ABNORMALS COMMENTARY

**PROPOSED RESIDENTIAL DEVELOPMENT
KERESFORTH ROAD, DODWORTH,
BARNSELY**

CP VIABILITY

**REV A
JANUARY 2026**

Drawing Title  
Masterplan

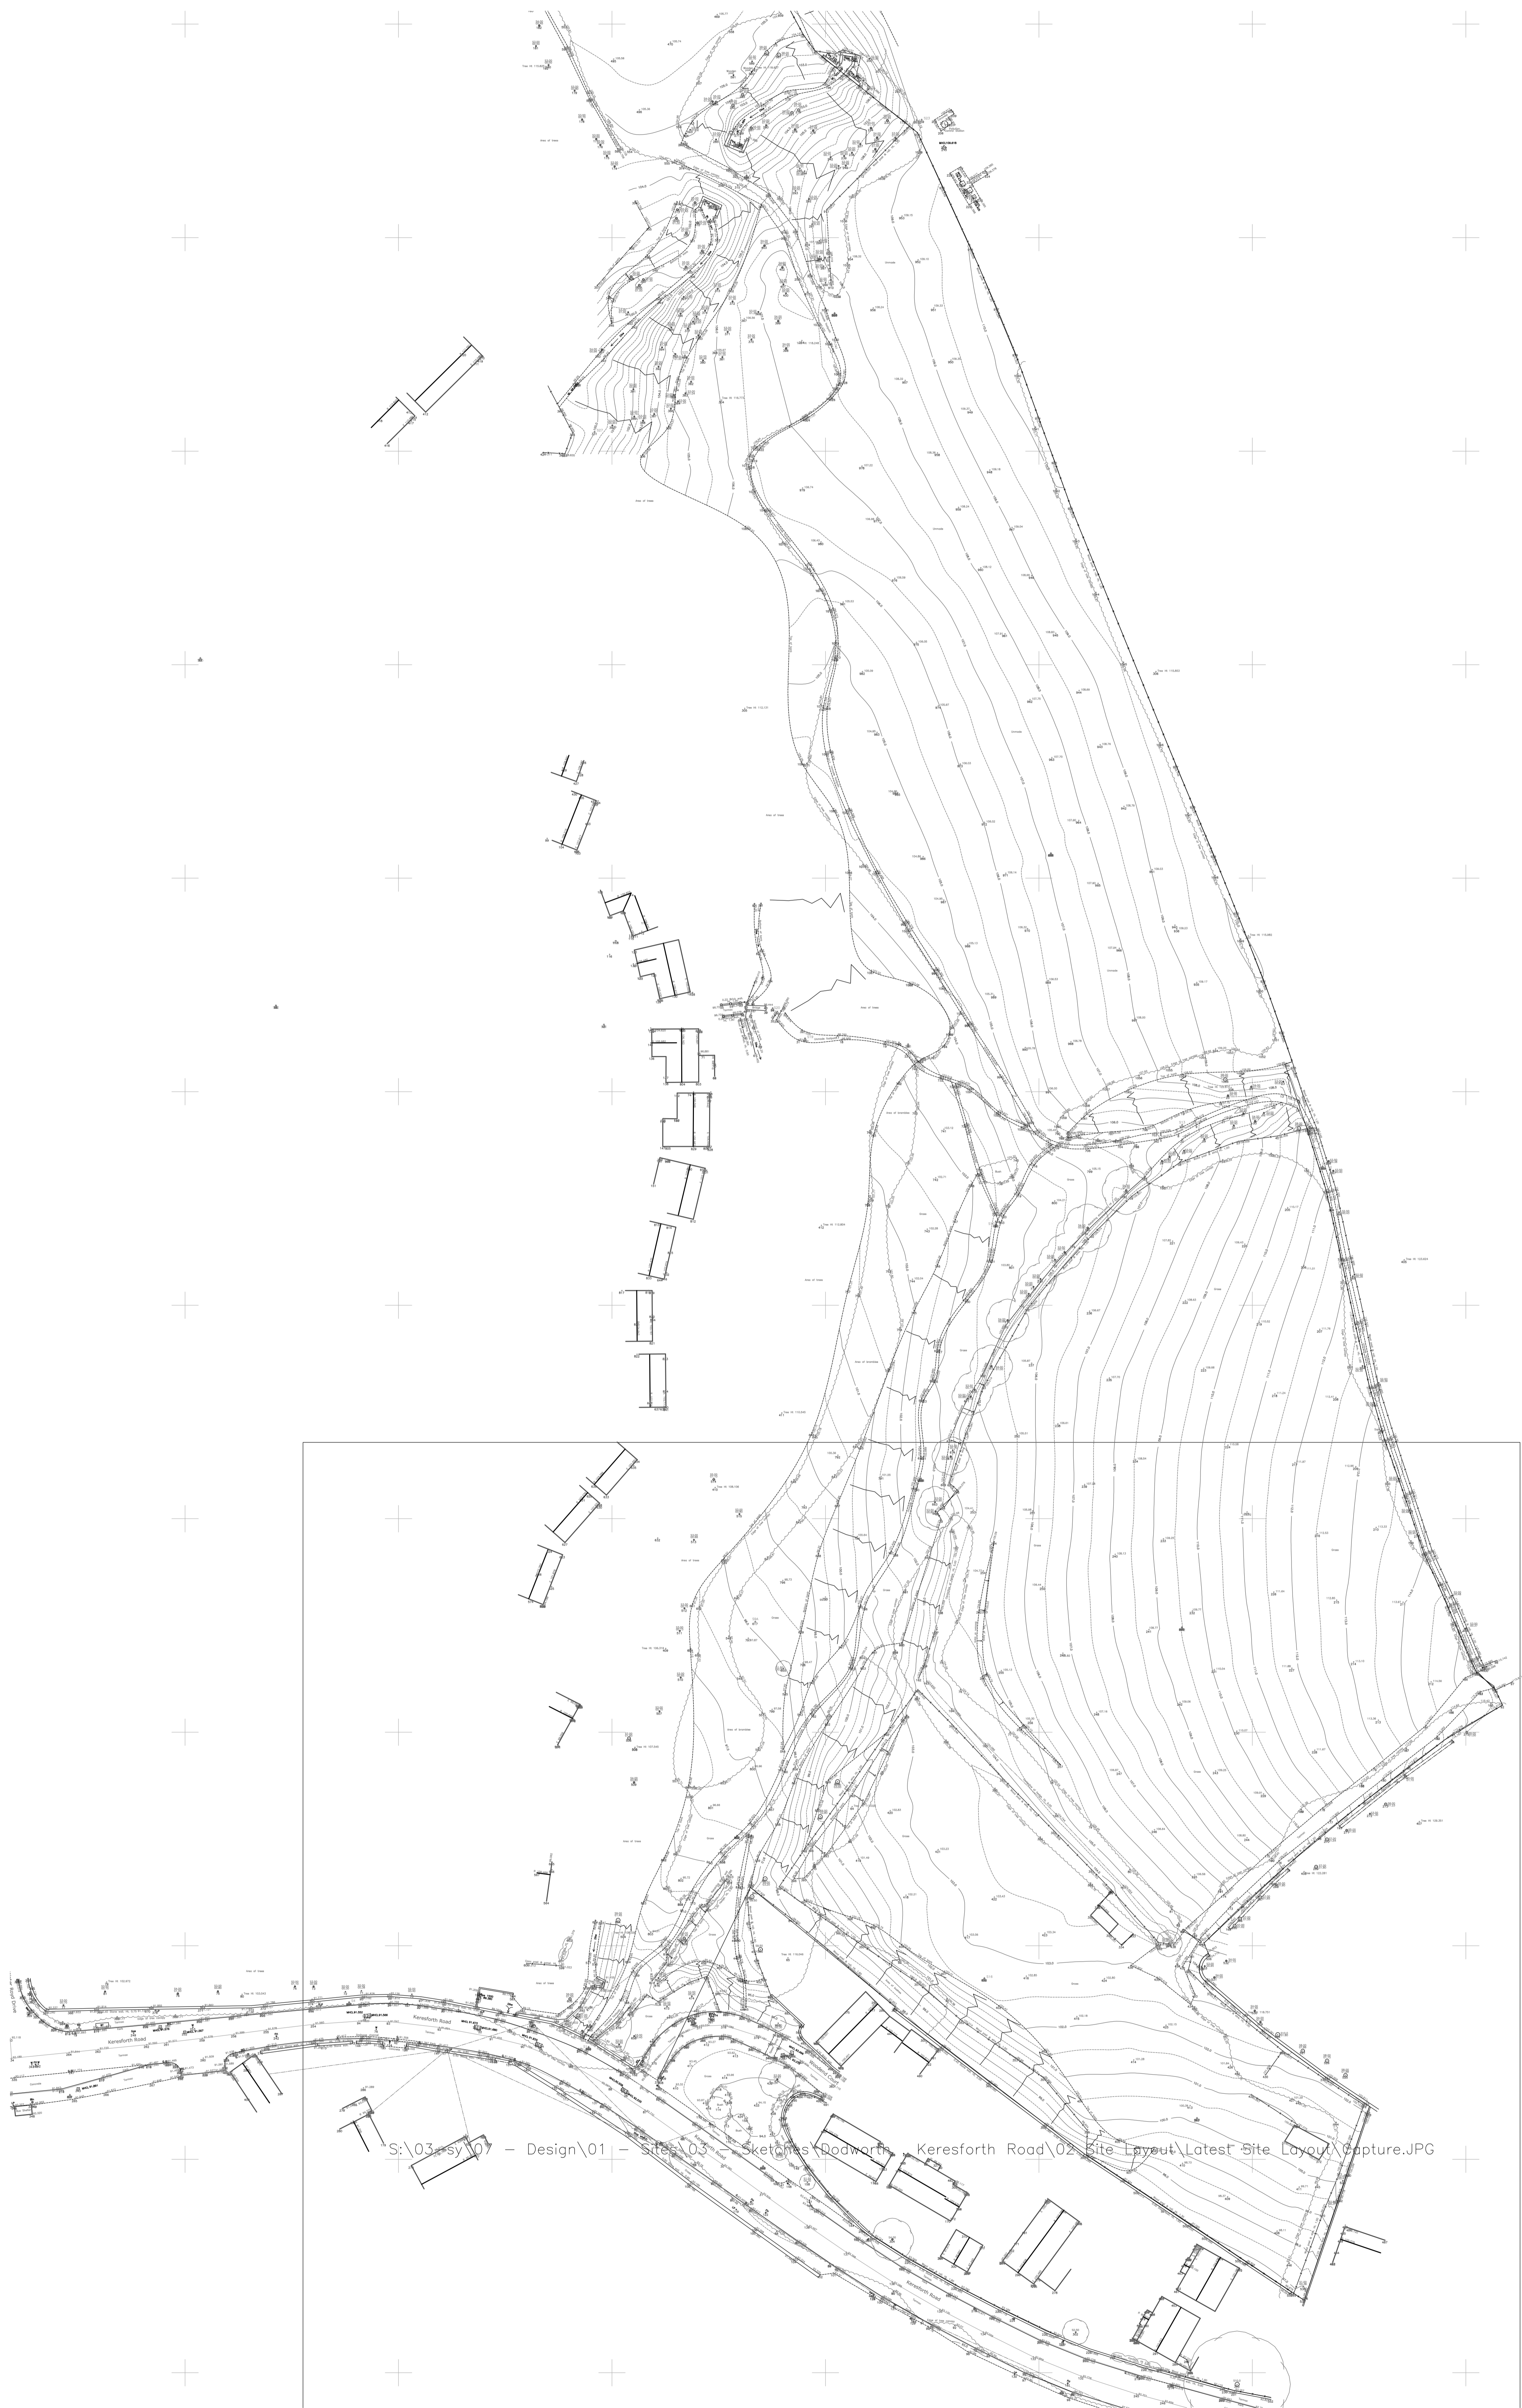
- 4.10 Externals – Public Open Space; 107,059
There are several areas extending and merging across the site shown on the Masterplan for public open spaces. We note the inclusion of proposed new pedestrian & cycle paths, a potential children’s play area, and other green spaces, and we consider that the £107,059 cost included appears reasonable.
